Communities Against Gatwick Noise Emissions (CAGNE)
Gatwick Airport Northern Runway project DCO application
PINS Reference Number: TR020005

CONSULTATION RESPONSE
PROJECT CHANGE 4

1. This is CAGNE’s response to the Applicant’s consultation in relation to proposed Project Change 4. Project Change 4 proposes provision of an on airport Wastewater Treatment Works facility. It is proposed due to ongoing uncertainty over the timescale for Thames Water’s (“TW”) upgrade works at its treatment plants to accommodate additional waste water flows from the Northern Runway Project (“NRP”).

ORIENTATION 	DRAWING NO. FIGURE 4.2.1c	REVISION For ES Issue
	DRAWN BY JM	PM / CHECKED BY KC

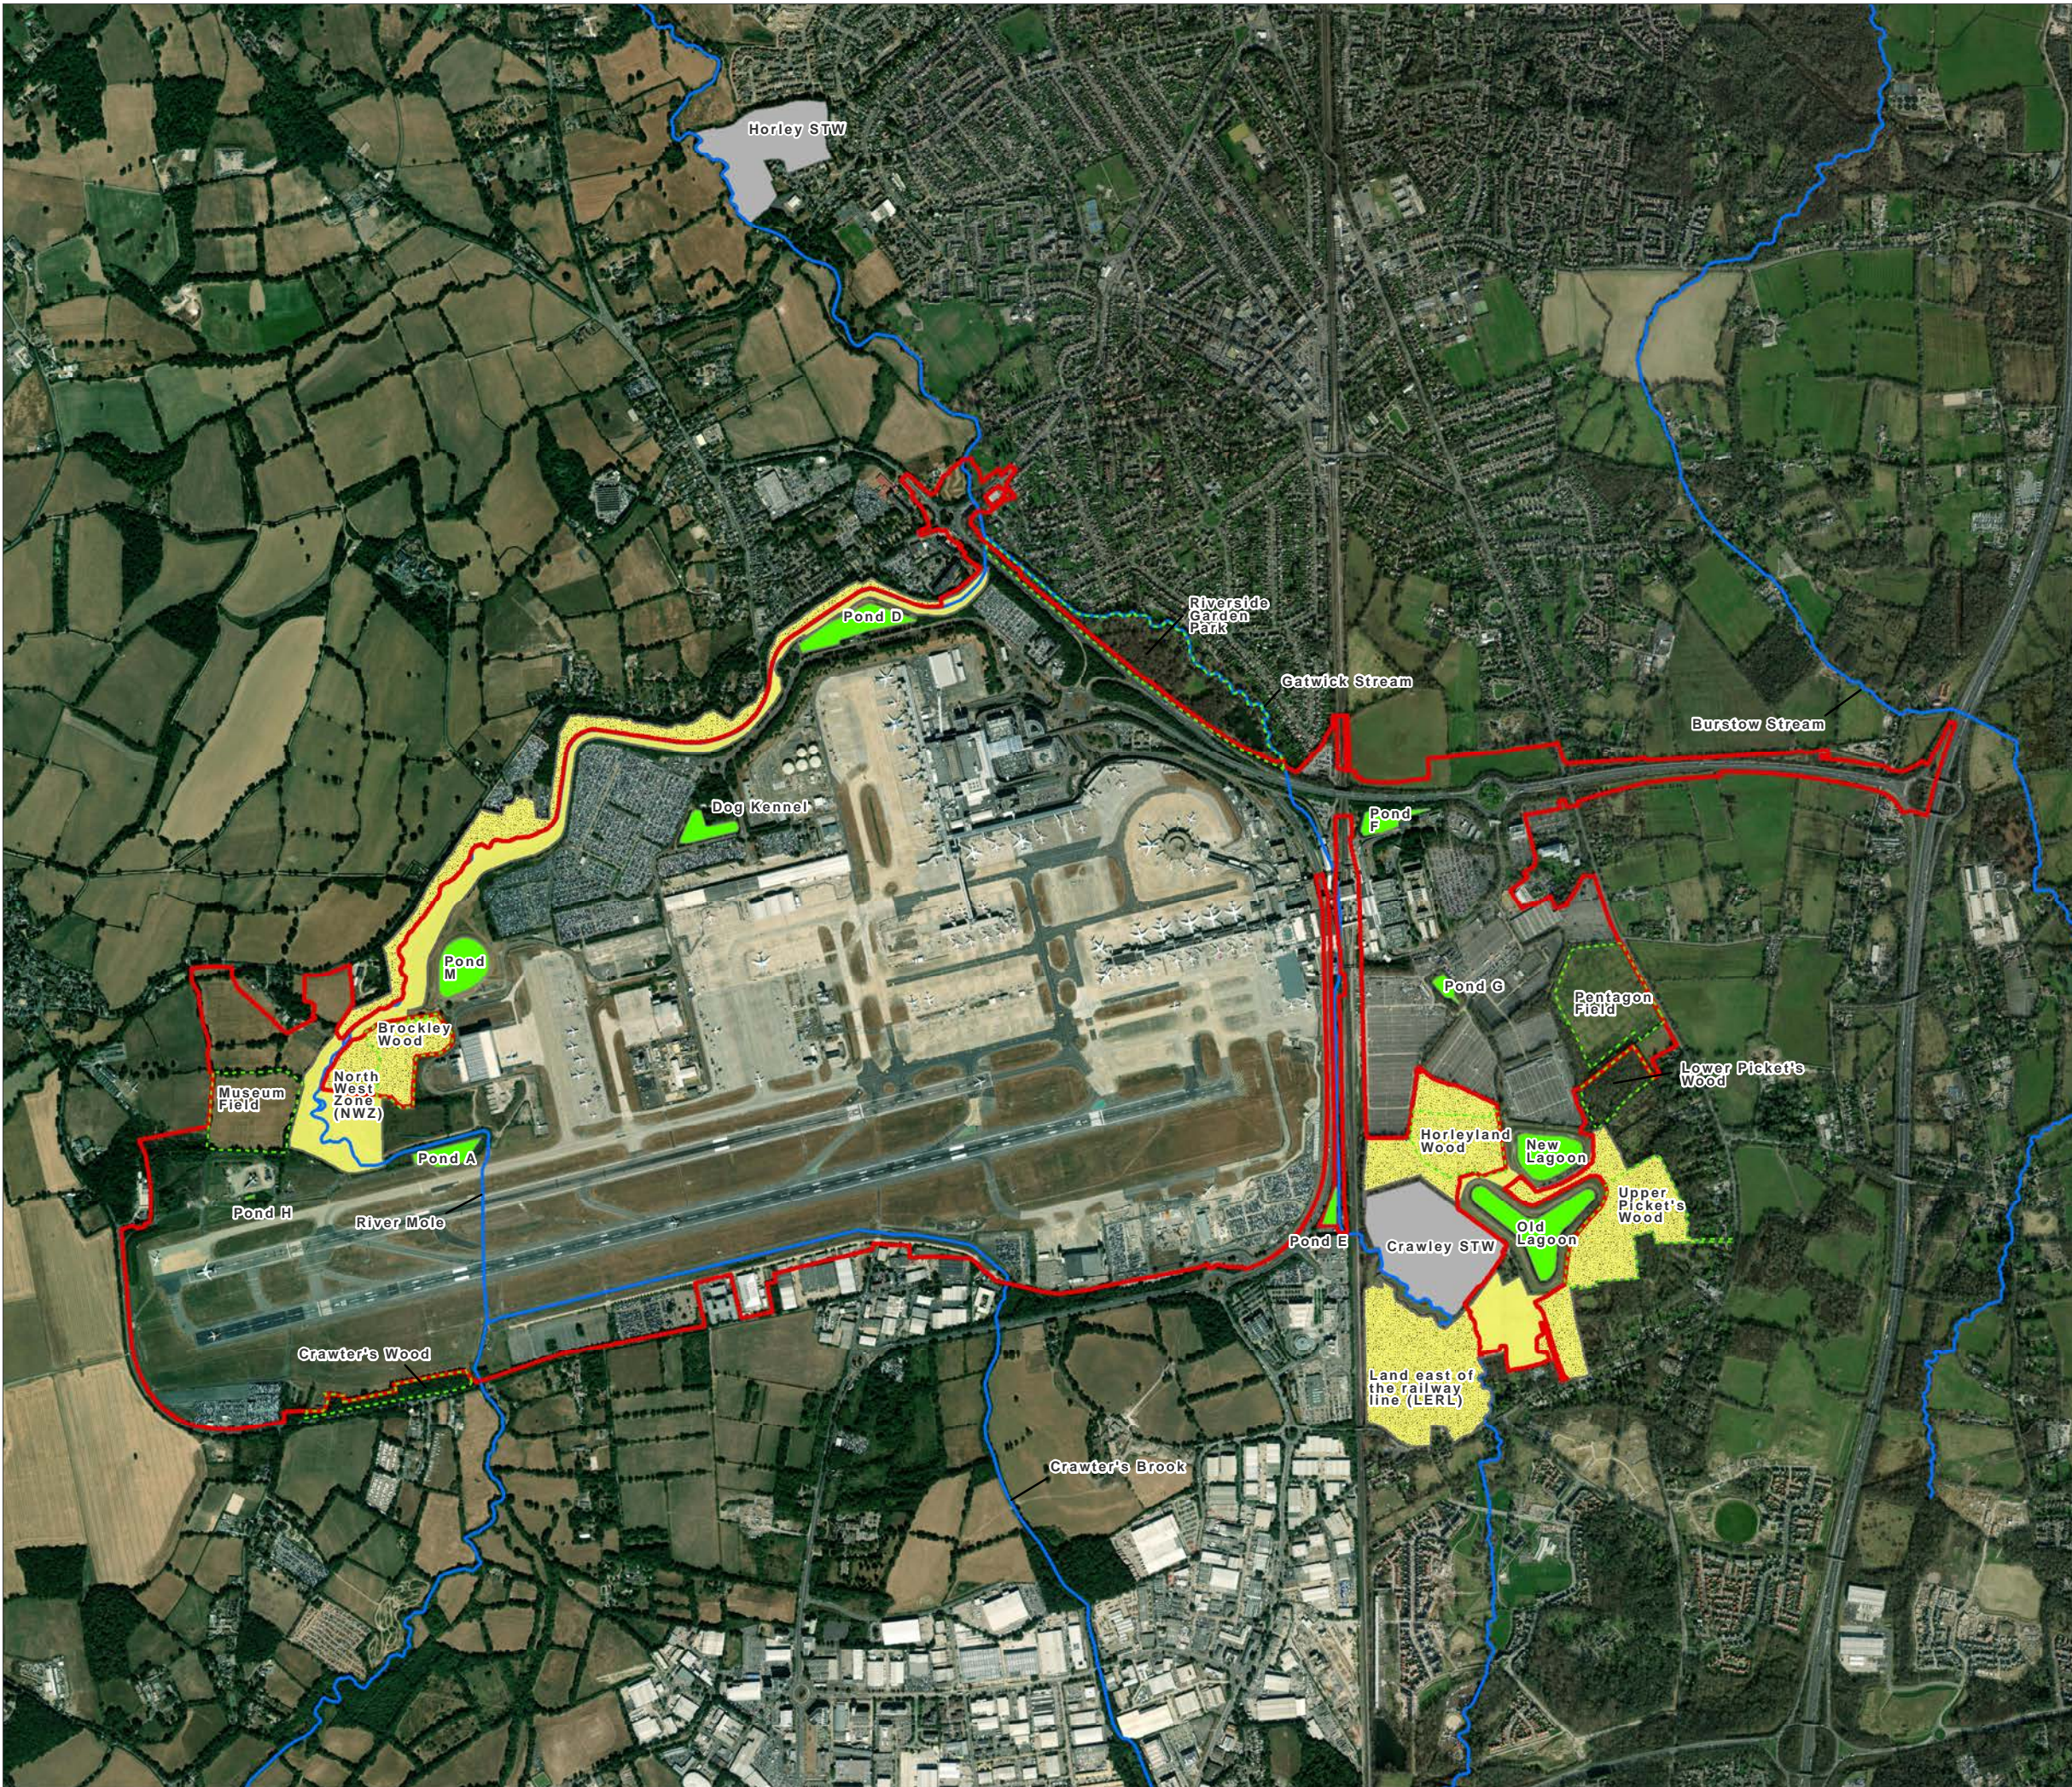
- c. The Applicant's materials do not provide any consideration of the proximity of the proposed facility to Pond M, the kennels, or the biodiversity areas.³
